Comments for Planning Application 24/00225/FULL6

Address: 30 Manor Park Close West Wickham BR4 0LF

Proposal: Demolition of existing rear extension. Construction of part one/two storey rear/side extension.

PROPOSED REAR

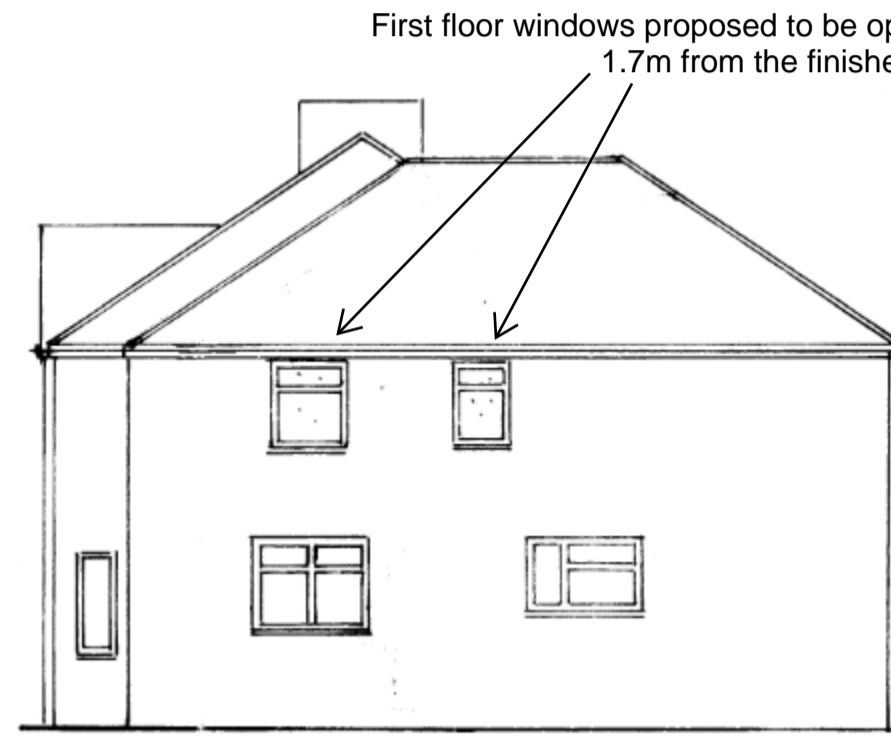
However, in the proposed side and rear extension, we do object to the placement of two windows ("Windows A") to the side of the first floor and the master bedroom window ("Window B") to the rear of the first floor. Given the proposed extension, which will be significantly closer to our living room and garden, the Windows would look directly into our living room and garden and will be a breach of our right to privacy.

We would like the opening pane of Window B that is closest to us either to be removed from the proposed works or for a guarantee to be given that the opening pane of Window B that is closest to us will be opaque or otherwise obscured, so a person looking out of the window would not be able to look into our living room and garden.

PROPOSED SIDE

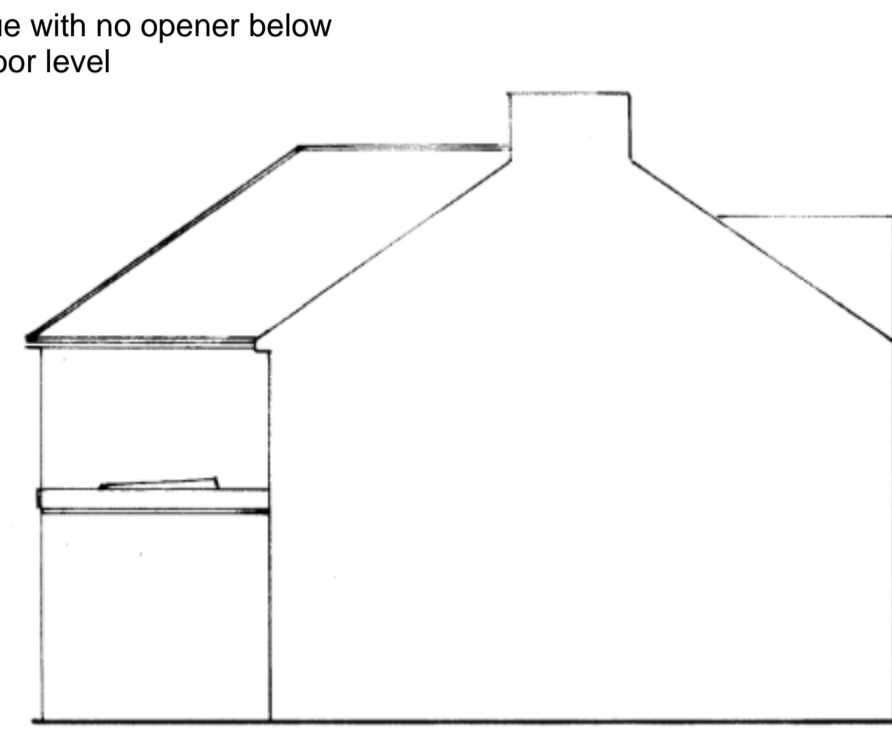
We would like the Windows A either to be removed from the proposed works or for a guarantee to be given that the Windows will be opaque or otherwise obscured, so a person looking out of the window would not be able to look into our living room and garden.
